Rezoning Transportation Analysis

Petition Number: 2020-057

General Location Identifier: Tax ID11303105A

Date	Description
05-18-20	First Review
06-29-20	Second Review

Schematic Site Plan Rezoning Petition #2020-057

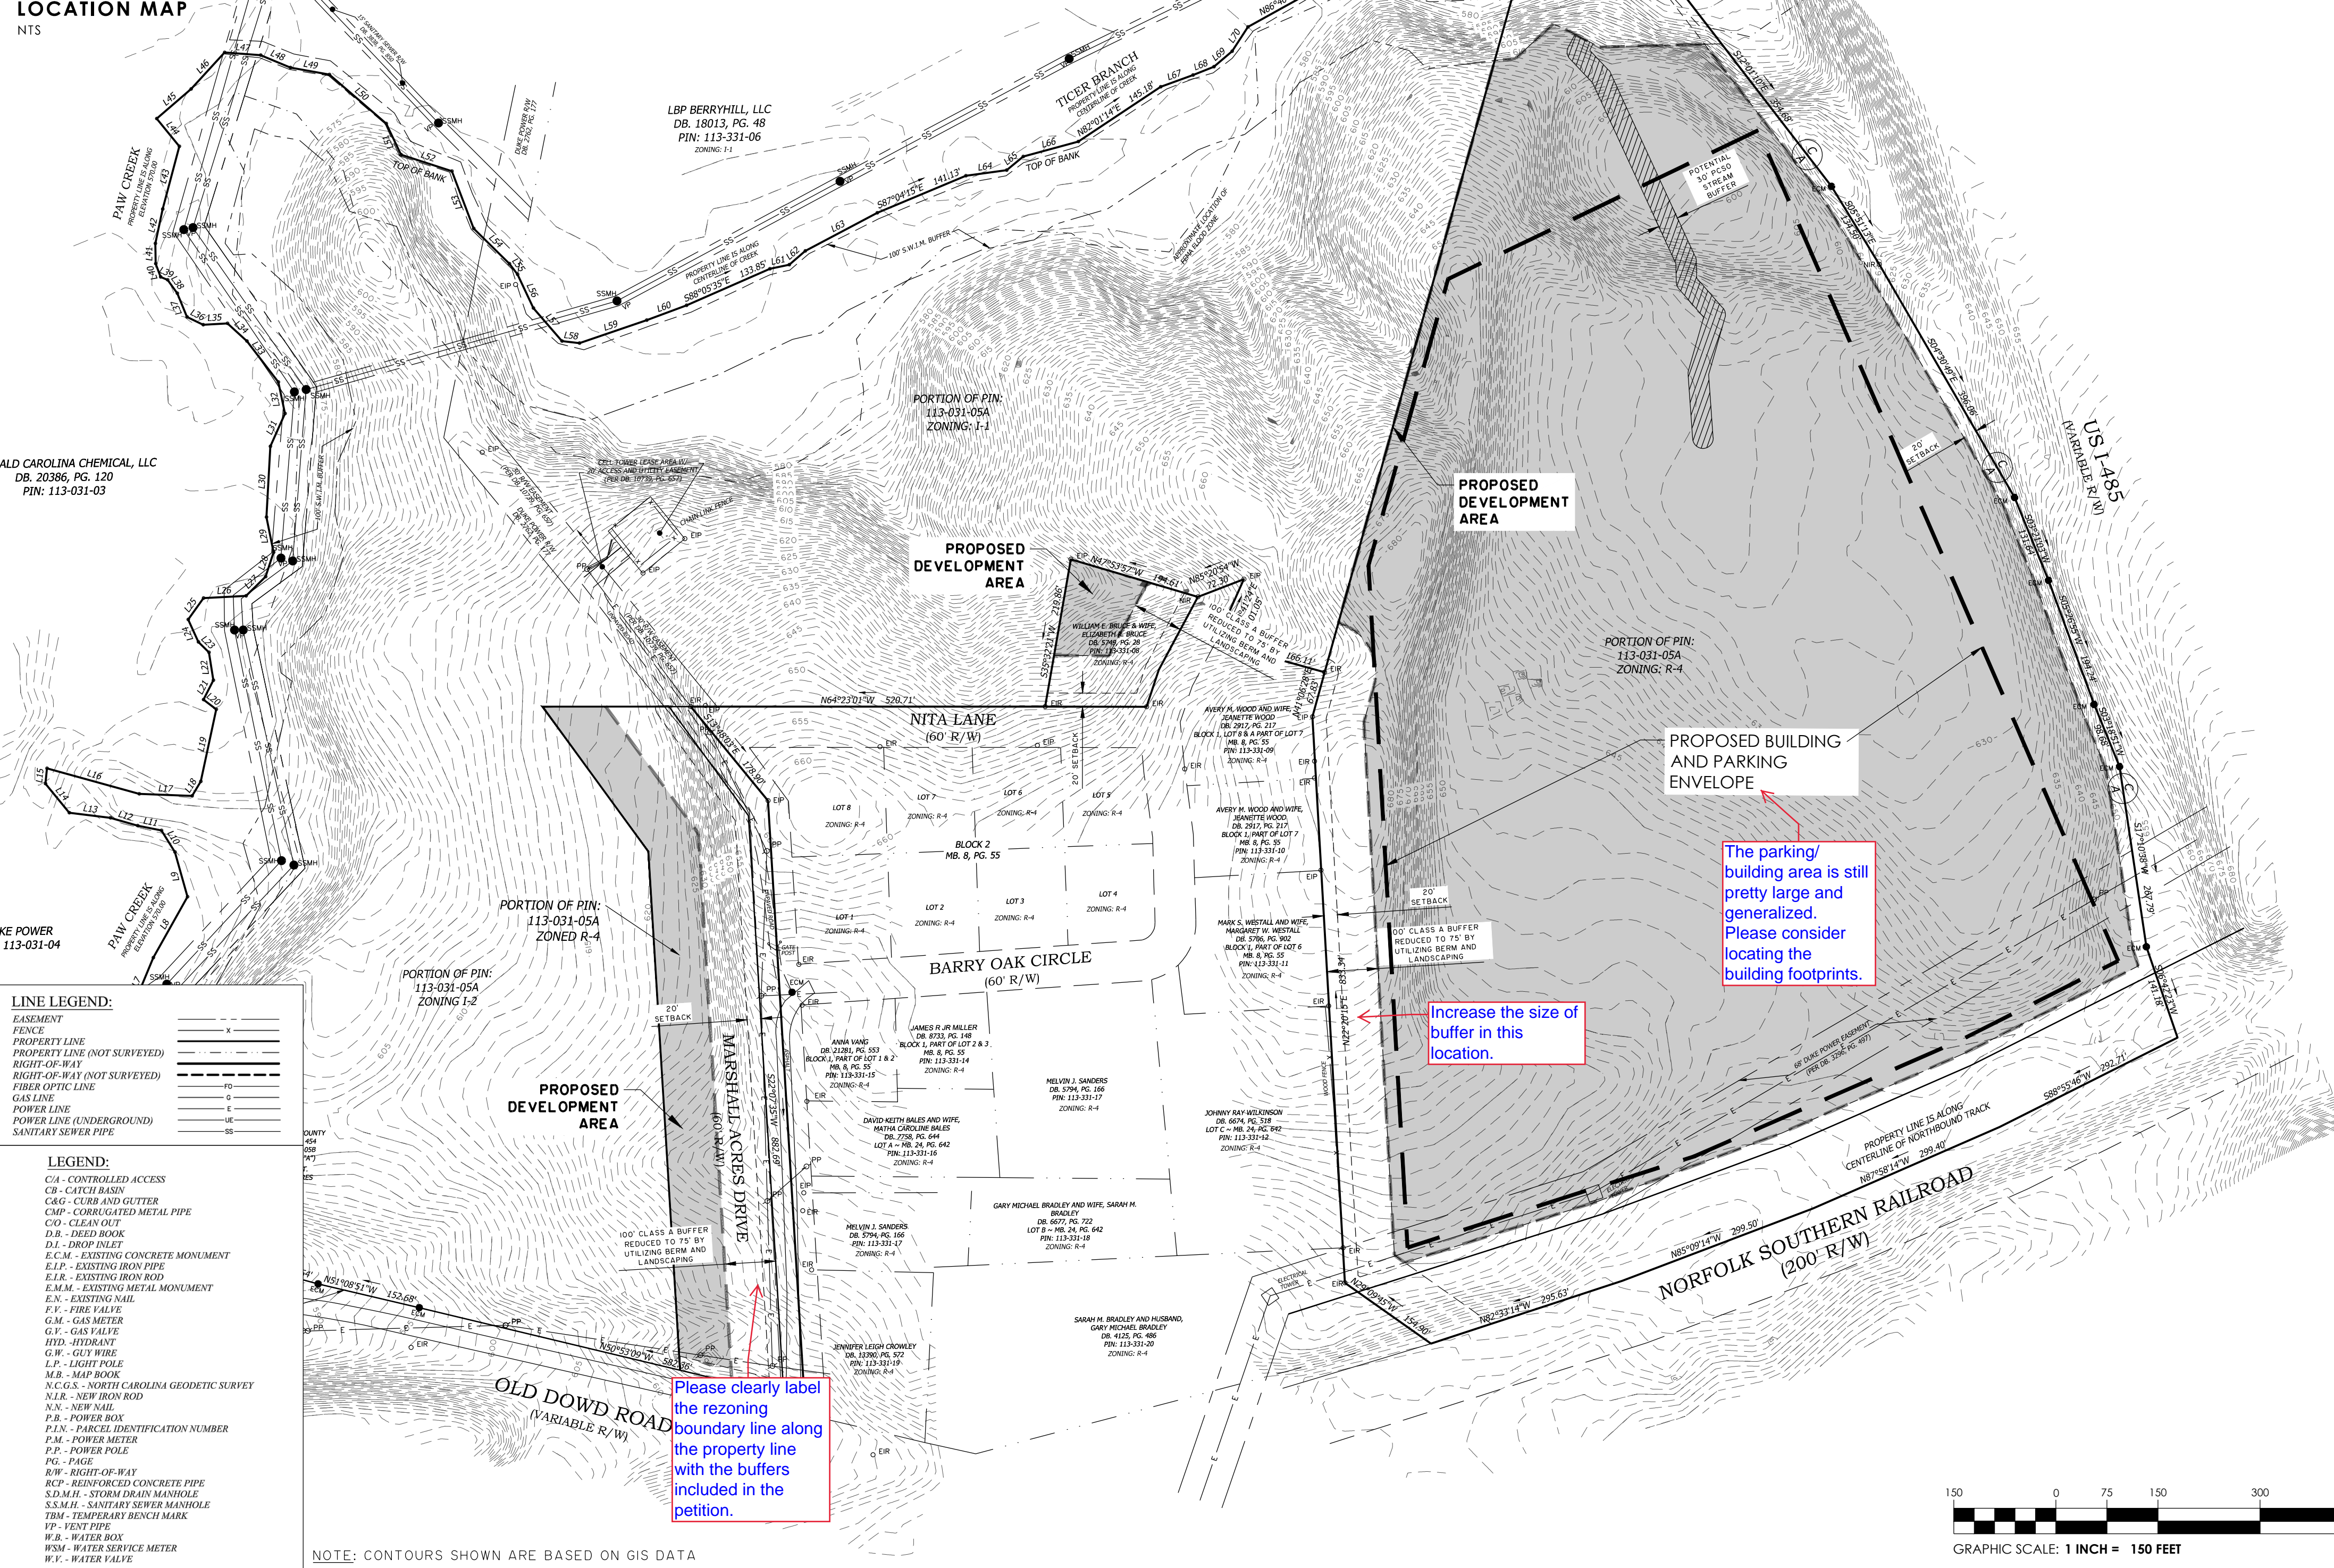
- a. **New comment based on 6/15/20 site plan:** The petitioner should revise the site plan and conditional note(s) to reserve 120-feet of right-of-way for the Comprehensive Transportation Plan (CTP) future 4-lane grade-separated crossing for the realignment of Old Dowd Road.

3. **New comment based on 6/15/20 site plan:** The petitioner should revise the site plan and conditional note(s) to show the proposed access(es) to the site. It is not clear if the petitioner is proposing to use Marshall Acres Drive as the access, or if there would be an access parallel to it, or something else entirely. Comment #4 below will still apply to any new access(es) regardless of location.

4. **Outstanding** The petitioner should revise the site plan and conditional note(s) to construct right and left-turn lanes at the proposed access on existing Old Dowd Road. An internal 3-lane section should also be designed to accommodate the future realignment of Old Dowd Road.

5. **Outstanding** The petitioner should revise the site plan and conditional note(s) to commit to construct an 8-foot minimum planting strip, and 6-foot sidewalk on existing Old Dowd Road per Chapter 19 of the City Code. The site plan should label and dimension both items from the edge-of-pavement/shoulder and road centerline.

6. **Outstanding** The petitioner should revise the site plan and conditional note(s) to commit to construct an overland connector along the future Paw Creek Greenway on existing Old Dowd Road to meet the City of Charlotte BIKES Policy and Greenway Master Plan.

7. **Outstanding** The petitioner should revise the site plan and conditional note(s) to confirm whether the proposed development will consist of one or two buildings, to determine applicability of the Subdivision Ordinance.
